EAST LIMERICK SUBSTATION DEVELOPMENT

Road Safety Audit Stage 1/2

Project Title	Proposed Substation at East Limerick
Project No.	25232-02
Document Title	Road Safety Audit Stage 1/2
Document No.	25232-02-001

SUBSTATION ACCESS - EXISTING

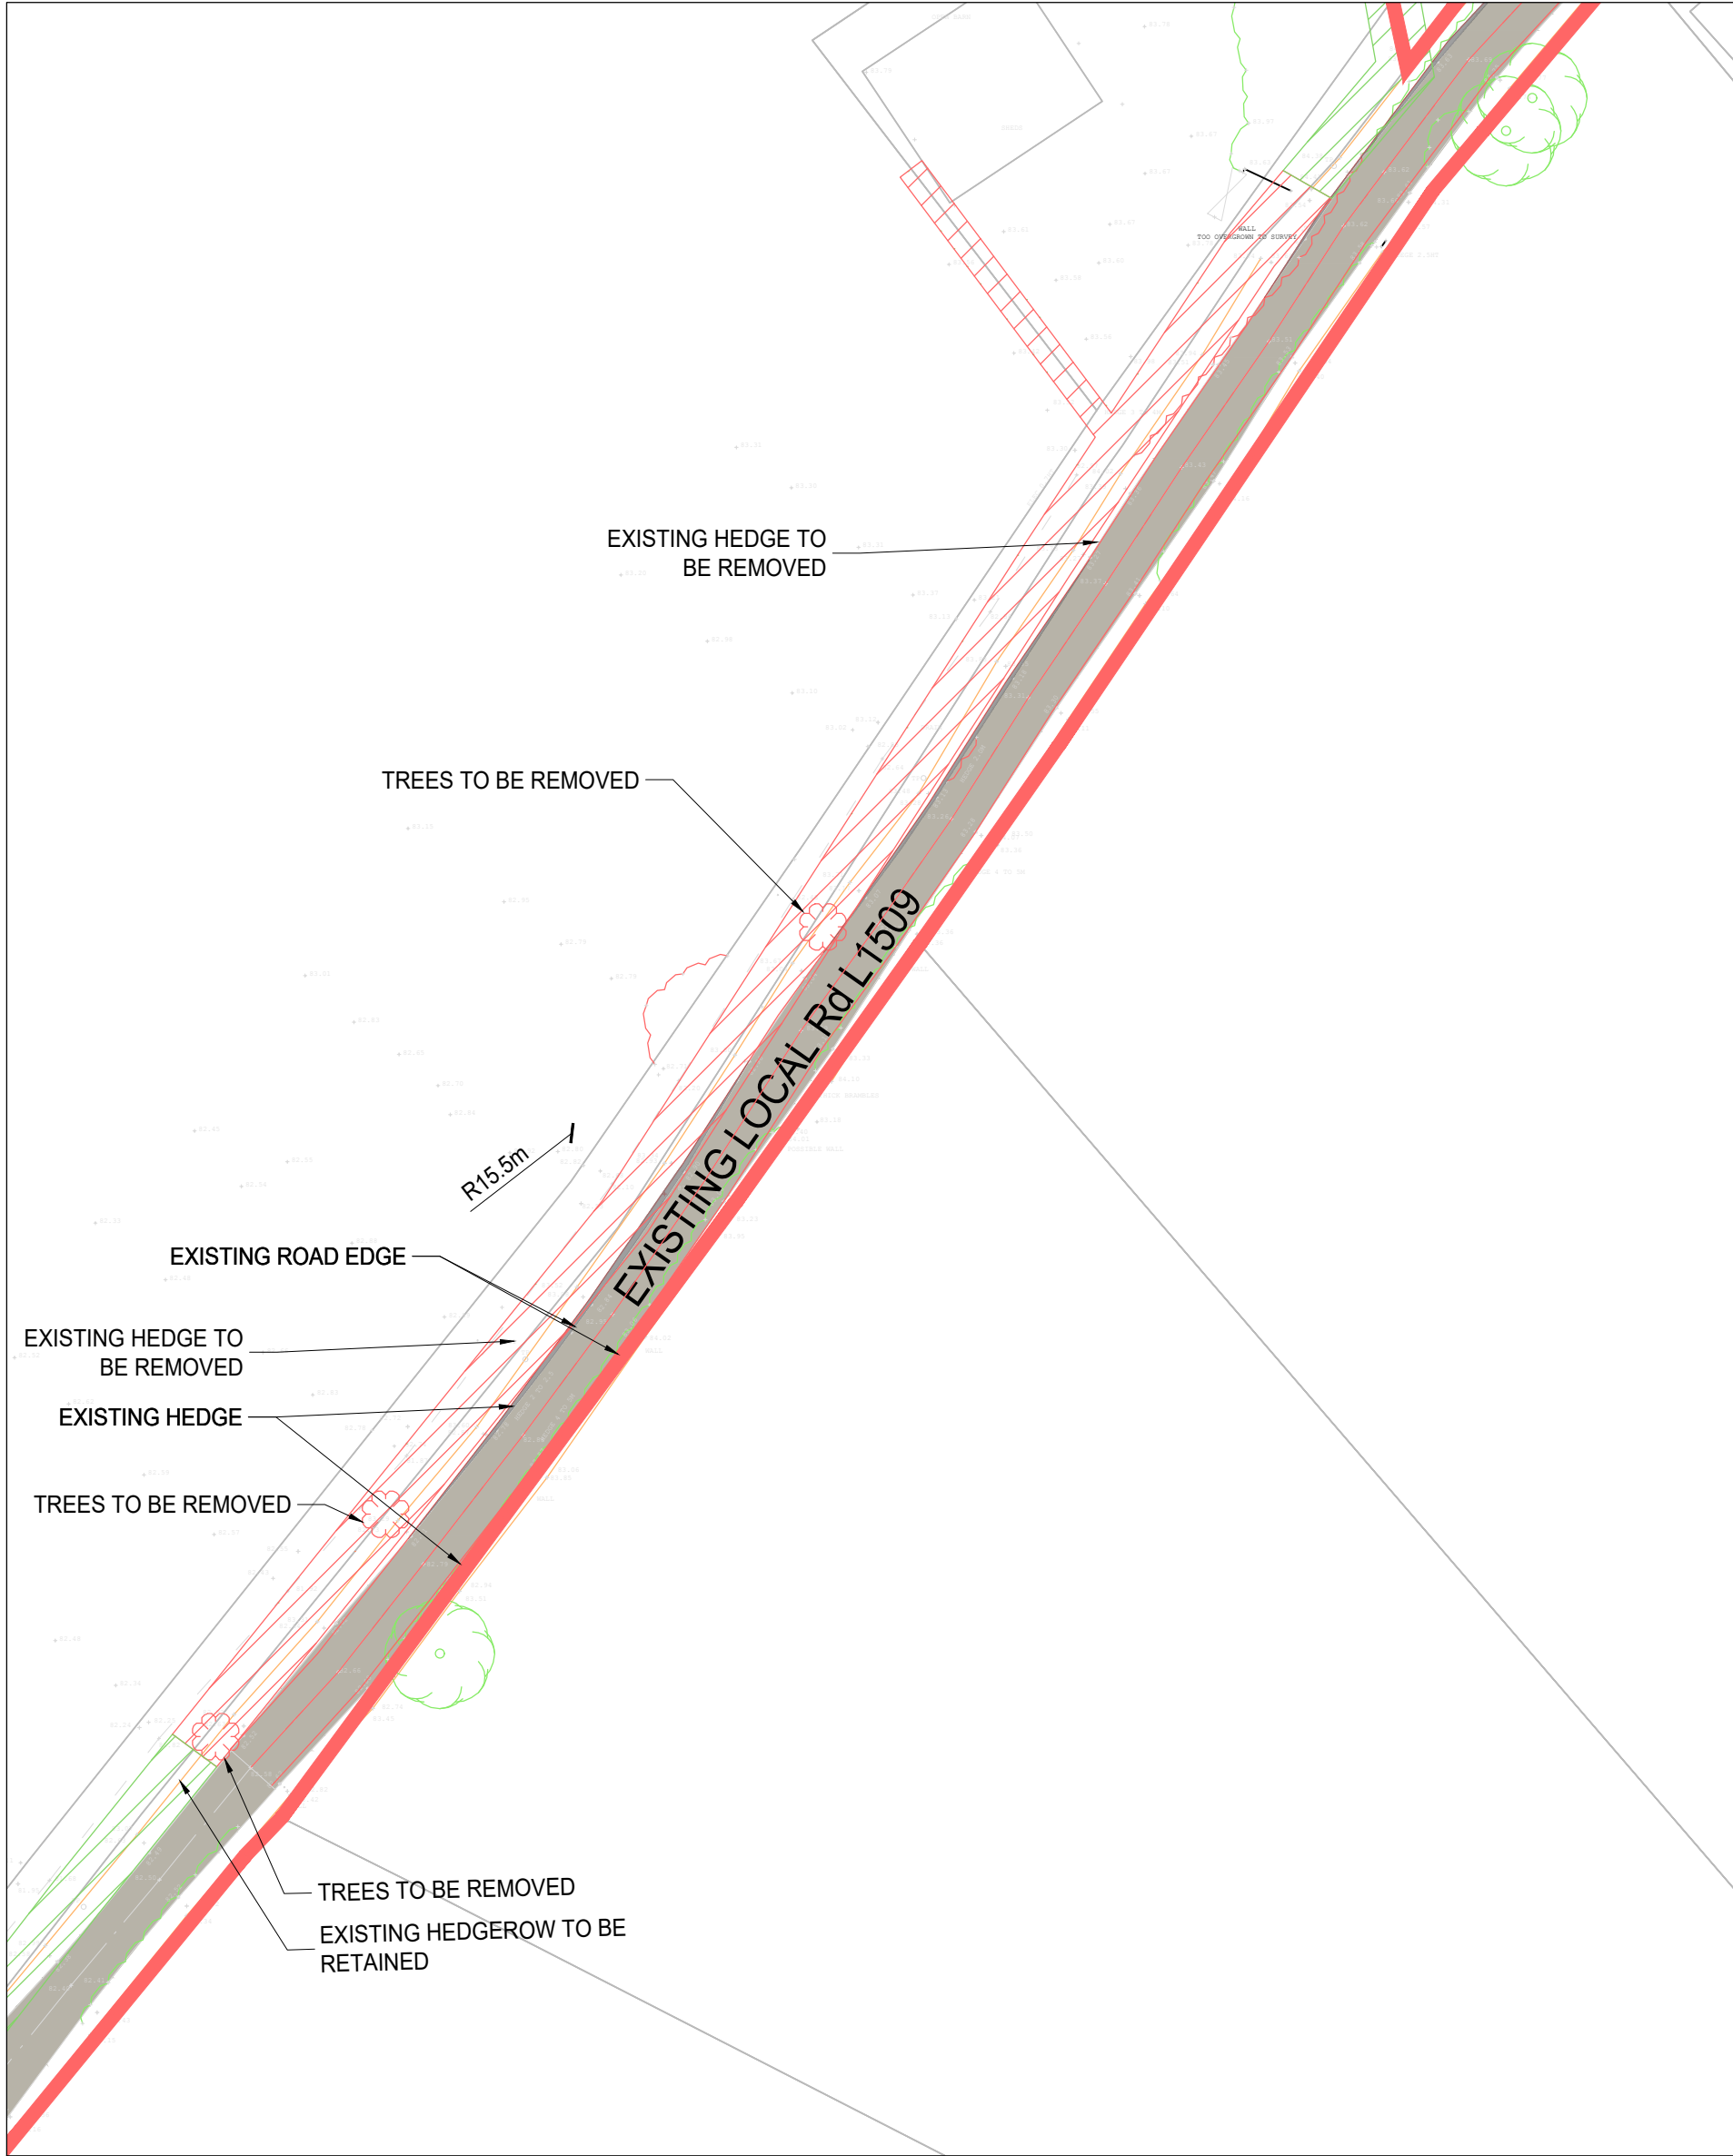
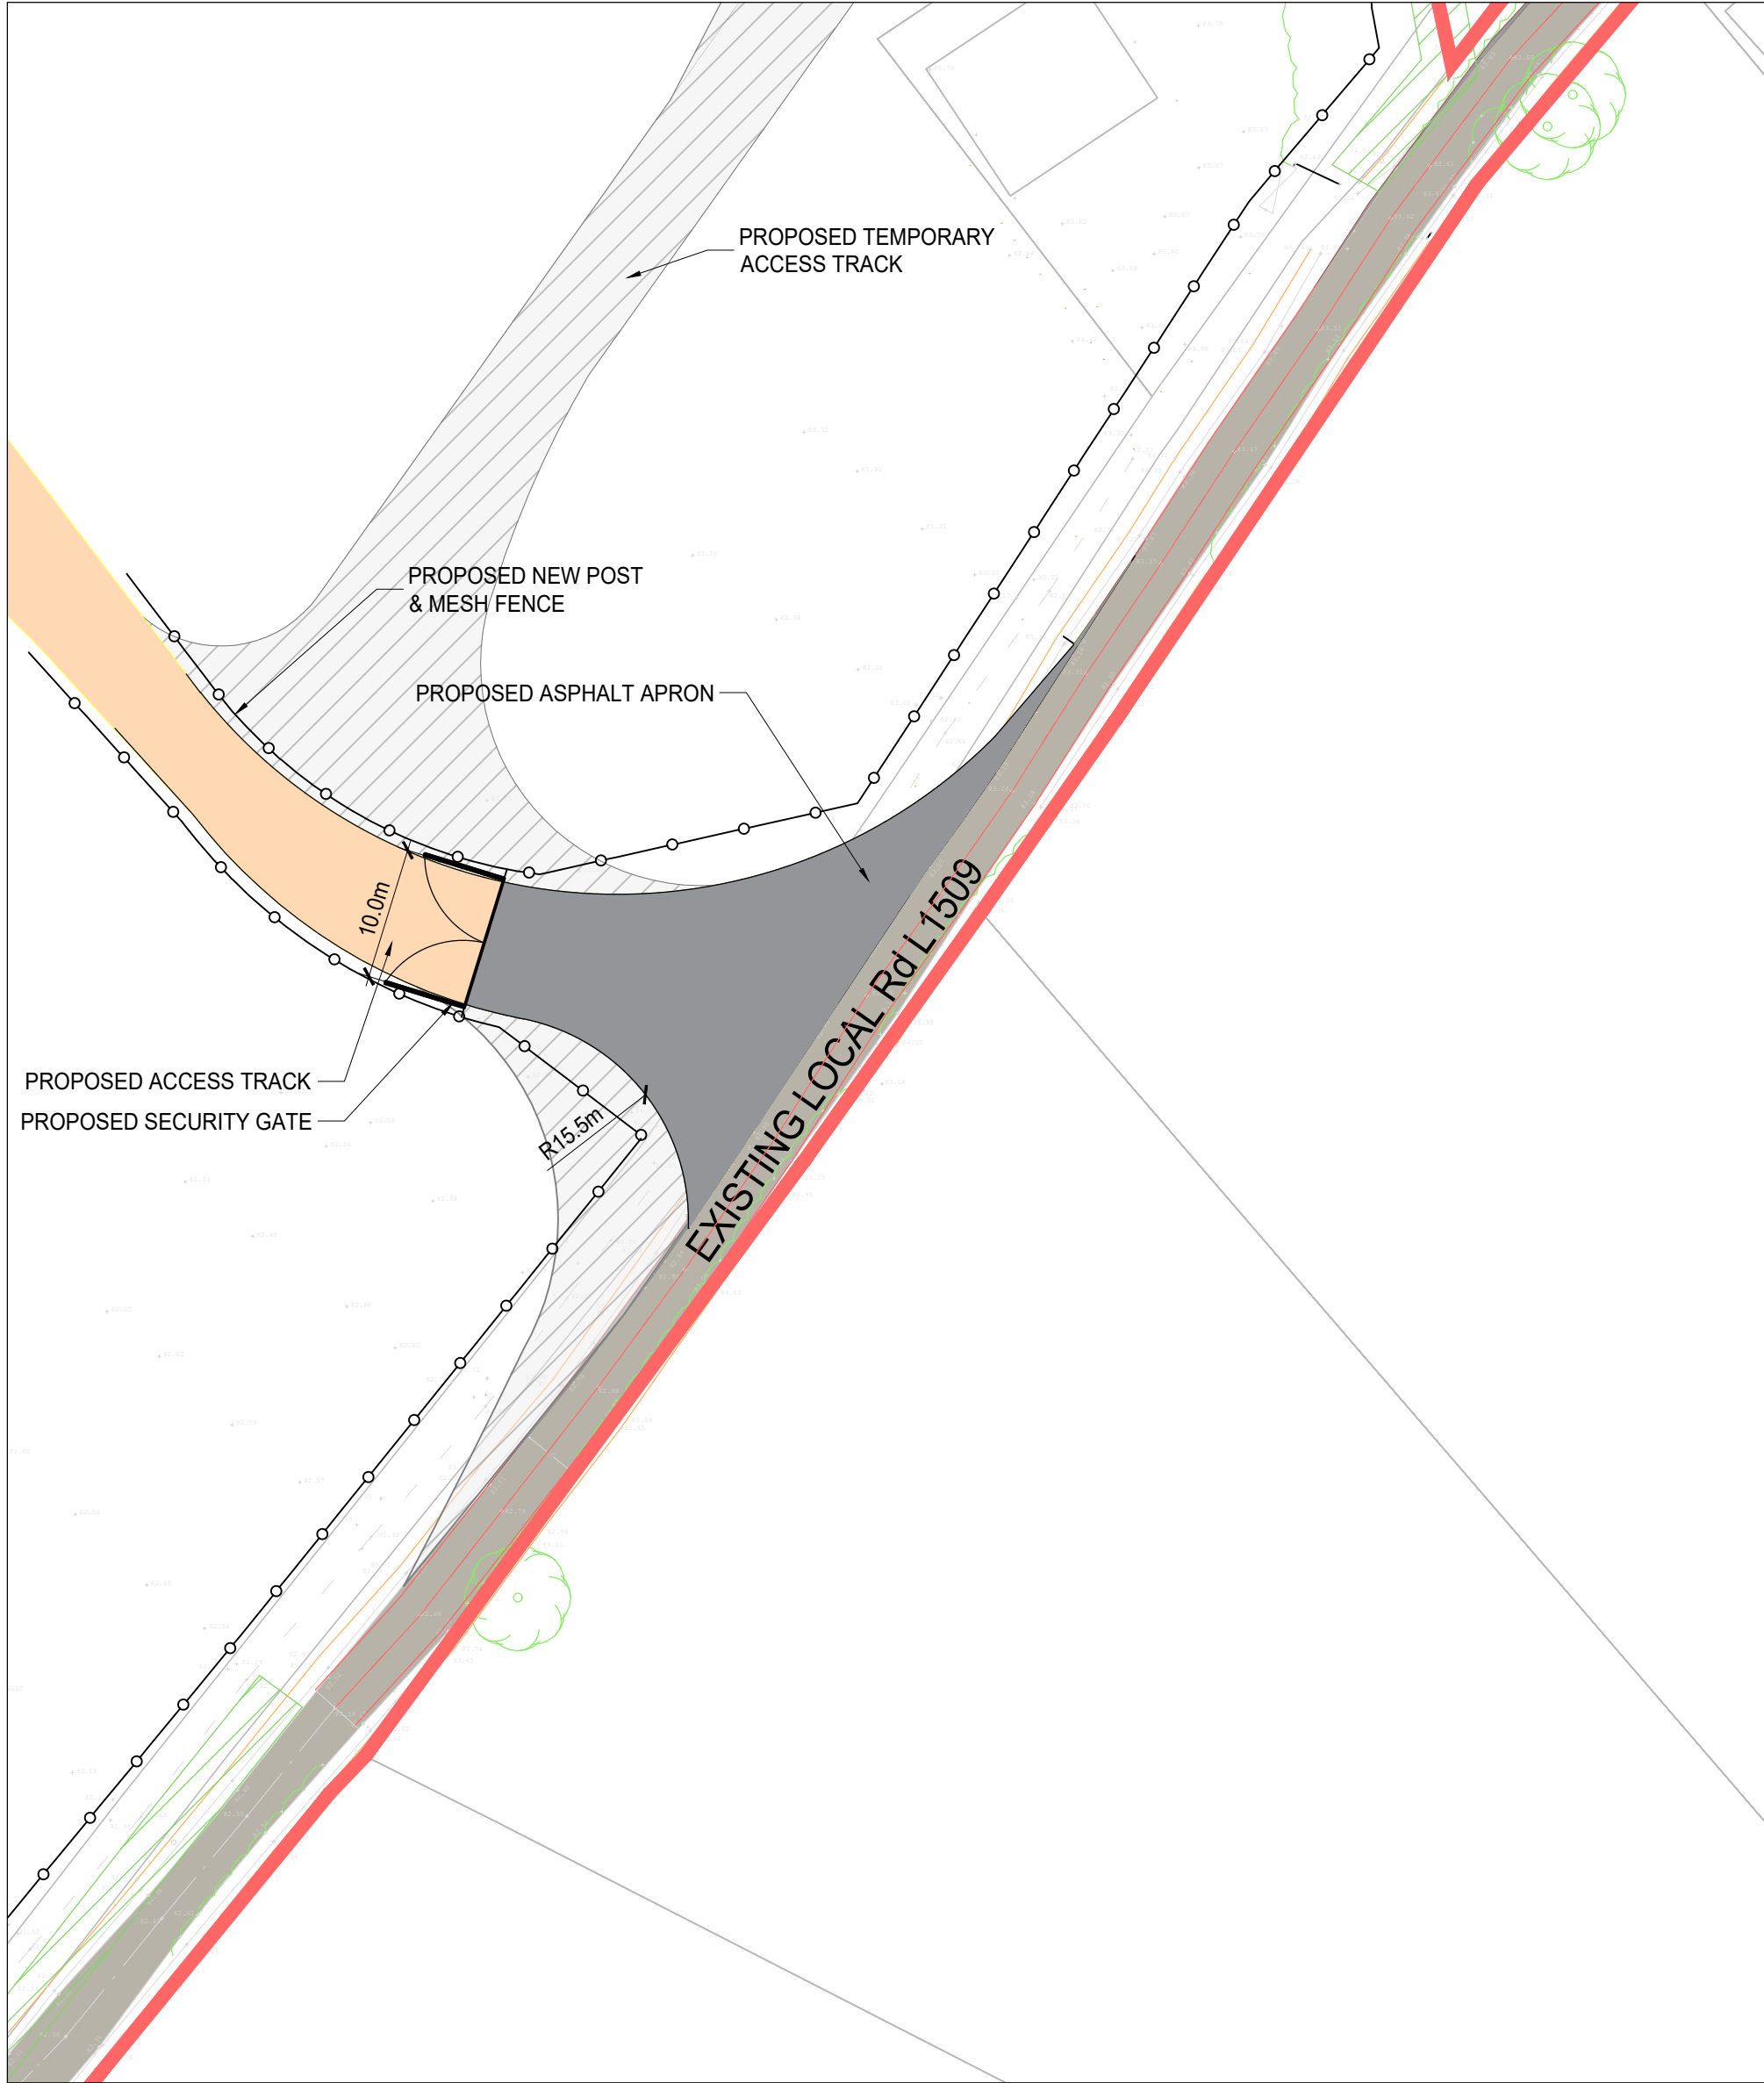
2.1 Problem: Skewed Angle

Location: Substation Access

The proposed development access intersects the local road at a skewed angle rather than at, or close to, a right angle. As a result, drivers exiting the development will be required to look back over their right shoulder to observe approaching traffic on the local road. This manoeuvre may reduce the effectiveness of driver observations and compromise intervisibility between exiting and approaching vehicles. Consequently, the likelihood of missed observations and vehicular conflicts may be increased.

Recommendation: Revise the alignment of the proposed development access to form a junction angle as close as practicable to 90 degrees with the local road.
